CITY OF ALBUQUERQUE

**RE: 5730 McMahon Blvd NW –McMahon Market Place New Shell Building
Grading Plan
Stamp Date: No Stamp Date
Hydrology File: A11D011E**

Based upon the information provided in your submittal received 5/8/2017, the Grading Plan **is not** approved for Building and SO-19 Permit. The following comments need to be addressed for approval of the above referenced project:

CG-1

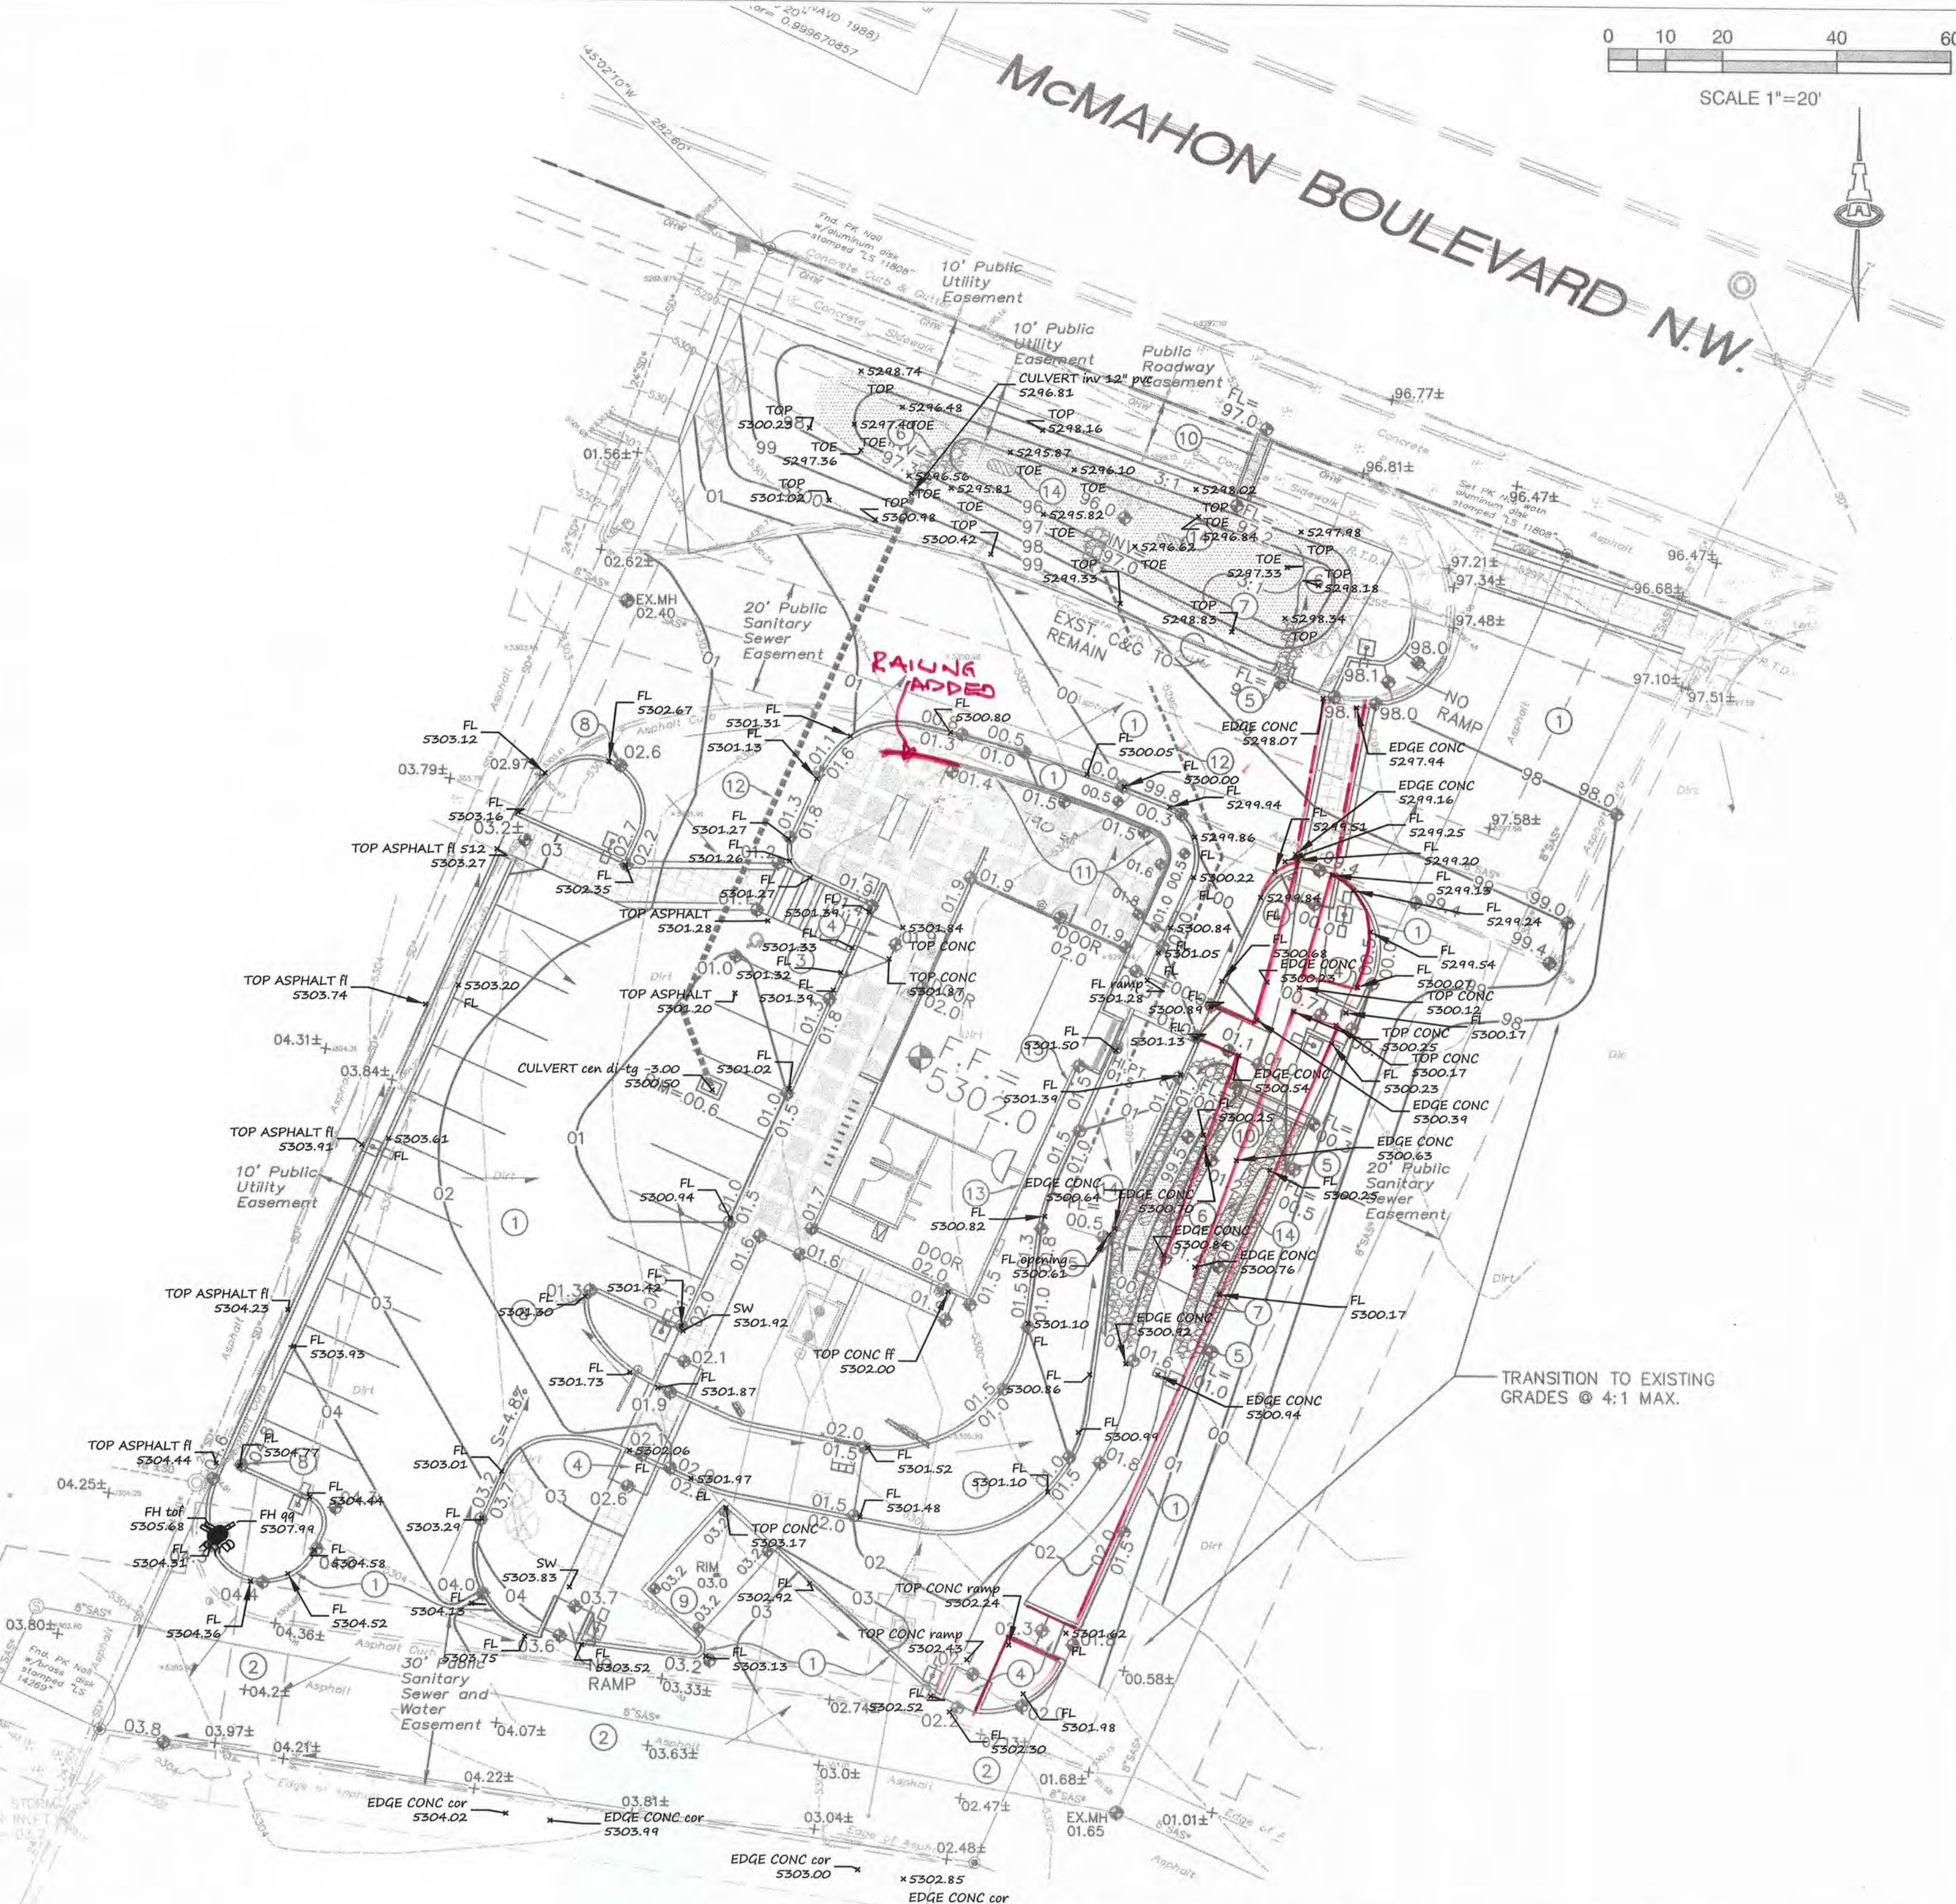
2. On Sheet CG-1. Please make the existing spot elevations readable. Checking the transition between proposed pavement and existing pavement is hard to do when the existing spot elevations are that small.

3. On Sheet CG-1. Please remove the future development along with any note letters and numbers. It is confusing in knowing what is being constructed, what is existing, and what is future development. Please clarify.

4. On Sheet CG-1. There is a proposed curb along a proposed drive or future drive on the east side of the property. It is hard to tell. If this is drive to be built with this submittal. If it is then a temporary curbing will need to be provided for where it has a future curbing. Please clarify.

5. On Sheet CG-1. There is a proposed curb along the exiting drive along the south property. Since it is noted that the existing asphalt drive is to remain, then is the south existing curb remaining or is there new curbing being installed. Please clarify.

6. On Sheet CG-1. There is an existing drive in the northern portion of the property. Is this to remain? The northern curb is to stay. If it is new then please show what the limits the existing drive is to be remove and what is to remain. If existing drive to remain, then there are proposed contours that should be tied into the existing drive contours instead. Please clarify.

7. On Sheet CG-1. There are two curb cuts for the first flush basin along the east drive. Are both curb cuts needed? It appears that the drainage from this drive enters the basin, was this basin sized to handle this flow? Please clarify.

8. On Sheet CG-1. There are easements shown. Please label the easements.
9. On Sheet CG-2. Under the Drainage Plan Concept, The McMahon Marketplace DMP is called out. This plan used 5% Type B, 10% Type C, and 85% Type D. This plan also calls for the commercial tracts are permitted free discharge as long as the future development detains the 8.4 cfs for the entire 12.13 AC McMahon Marketplace in either a pond or change the amount of landscaping (Type B) and impervious (Type D) amounts. The Unser/McMahon Area DMP, 2001 by Bohann-Huston calls for 90% Type D and 10% Type B. Please update this section. **This site will be able to free discharge under the McMahon Marketplace DMP,** however Lots 5-A, 6-A, 8-A, 9-A, 9-B, 9-C, and 9-D will have to follow the McMahon Marketplace DMP and detain the 8.4 cfs in a pond.
